Addendum No. 2

RE: Contract # C203875

Tyrrell-Dare Counties (B-5936)

Bridge #7 Over Alligator River On US-64

REVISIONS						SHEET NO.
NO.	BY:	DATE:	NO.	BY:	DATE:	TOTAL SHEETS
1			3			S-9
2			4			394

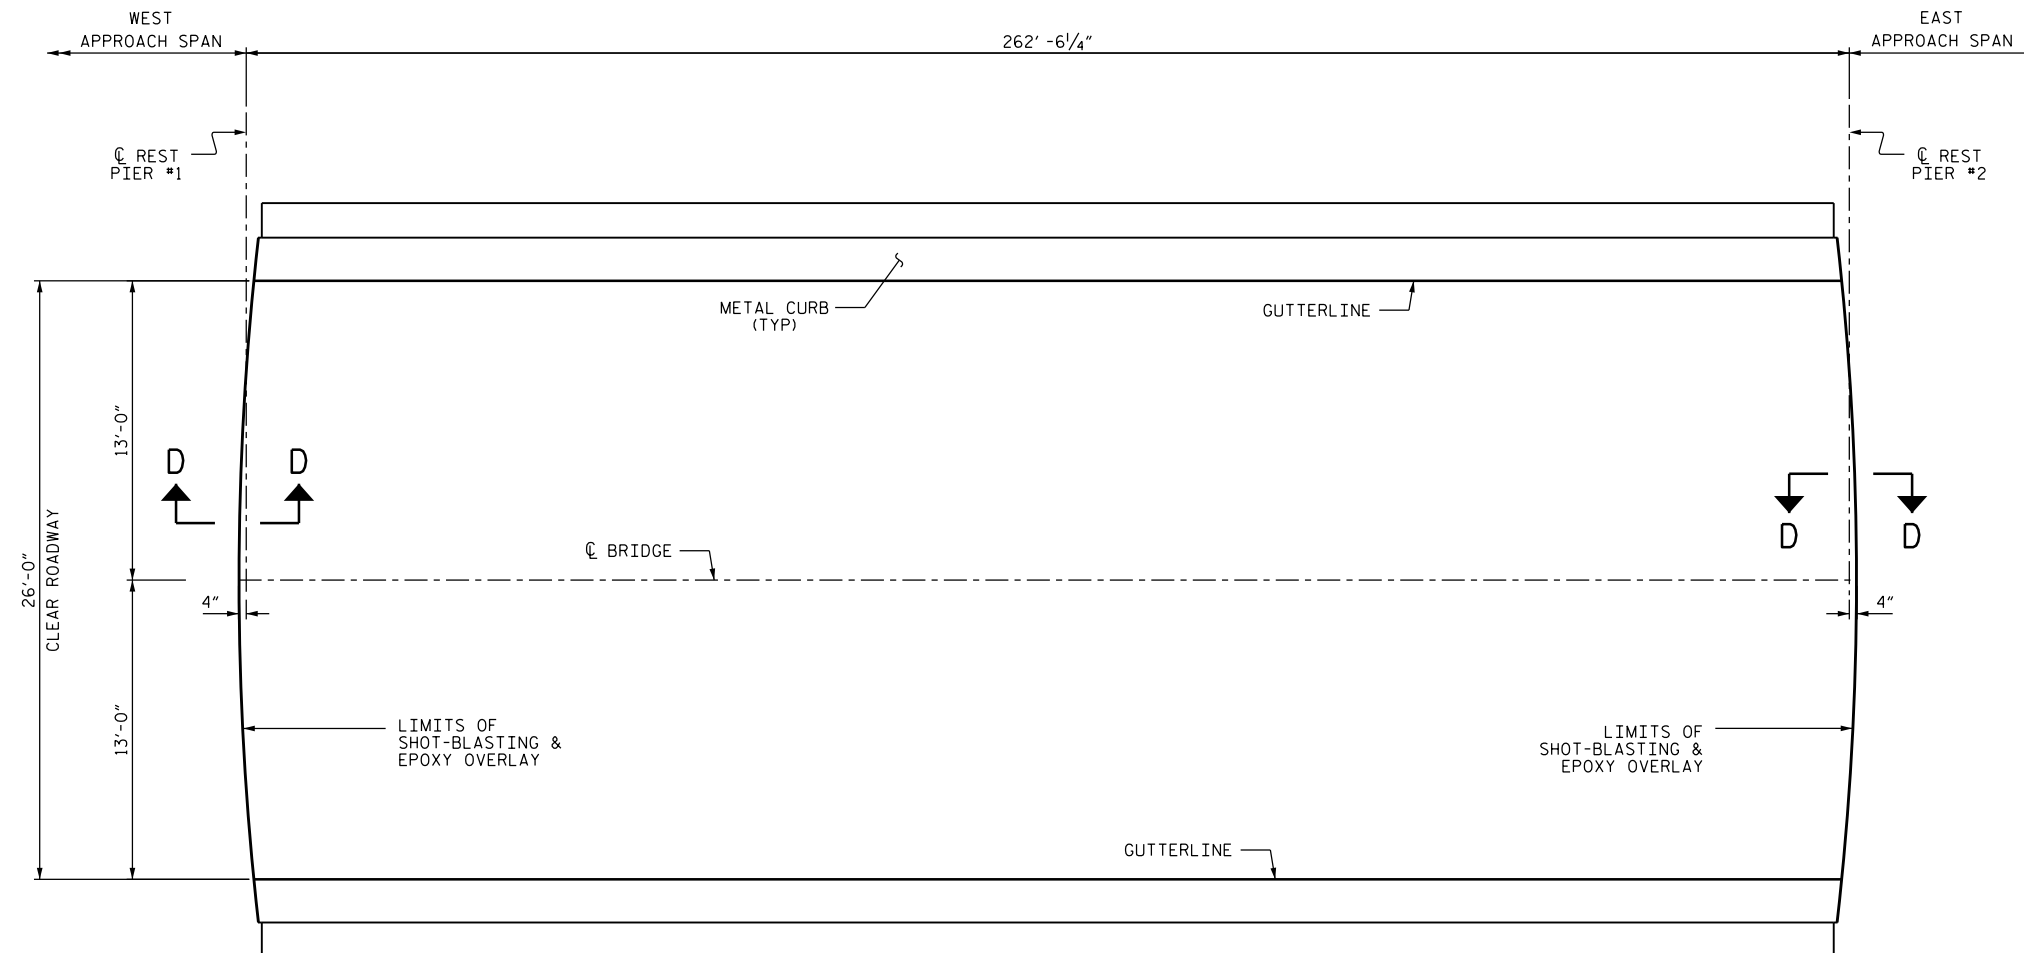
Sheet No.	Revisions
Title Sheet	Revised to change the Letting Date to December 20, 2016
1-A	Description of the "Type Of Work" was revised to add "Cleaning and Painting Existing Bearings"
S-1	Total Bill of Material was revised to reflect the addition of the three new pay items and the quantity change to one existing pay item as mentioned below
S-2	Revised to reflect the new scope of work items
S-5	Revised to add two new general notes for "Epoxy Mortar Repairs" and "Cleaning and Painting of Existing Bearings"
S-9	Revised to add new note concerning "Access Holes"
S-16 thru S-37	Revised to reflect new repair types

ACCESS HOLES FOR MANUAL OPERATION OF CAPSTAN AND WEDGE ANCHORS SHALL BE PERMANENTLY SEALED UPON COMPLETION OF MECHANICAL AND ELECTRICAL REHABILITATION OF SWING SPAN.

Drawing file: 400 Structure Plans - Bridges / 400_0769_B5936_SMU_S382_DIAPHGRAM_Repairs.pdf

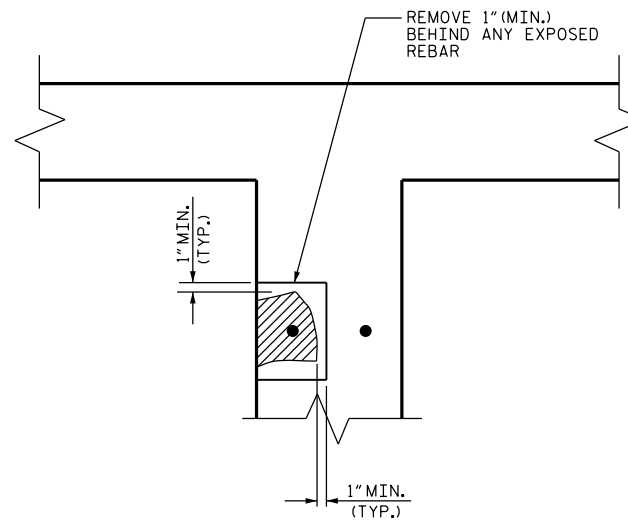
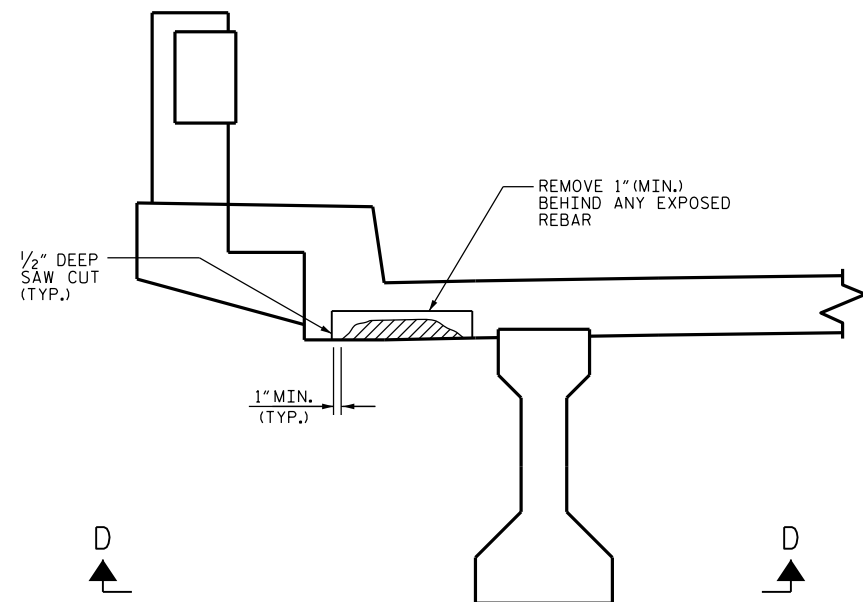
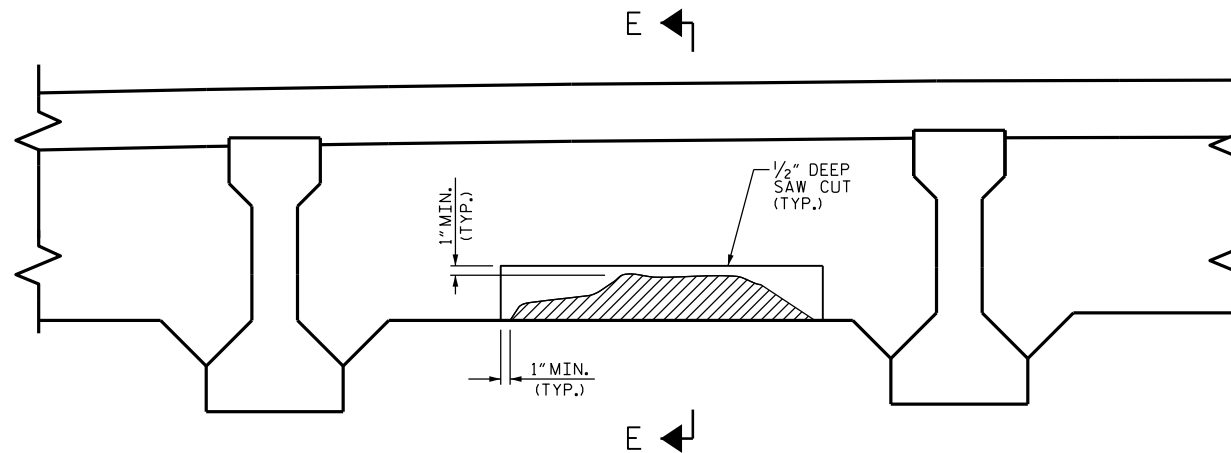
S-381	Revised to reflect new items of “Epoxy Mortar Repair” and “Clean and Paint Existing Bearings”. New notes were added. One note revised to allow “Epoxy Mortar Repairs” in lieu of “Shotcrete Repairs”
S-382	Revised to reflect new item of “Epoxy Mortar Repair”. New notes were added. One note revised to allow “Epoxy Mortar Repairs” in lieu of “Shotcrete Repairs”
S-391	Changes were made to clarify pile jacket repair requirements
A-1	Note 4 under “Scope of Work” was changed to reflect the change in scope concerning the handrails. The handrails shall now be completely replaced
A-2	Note 3 was changed to reflect the change in scope concerning the handrails. The handrails shall now be completely replaced
A-9	Note 8 has been modified and the location of the septic tank access ladder has been specified
A-10	Note 2 has been added to specify type for access ladder for septic tank. In the plan view and Section B-B the callout of the access ladder location has been modified
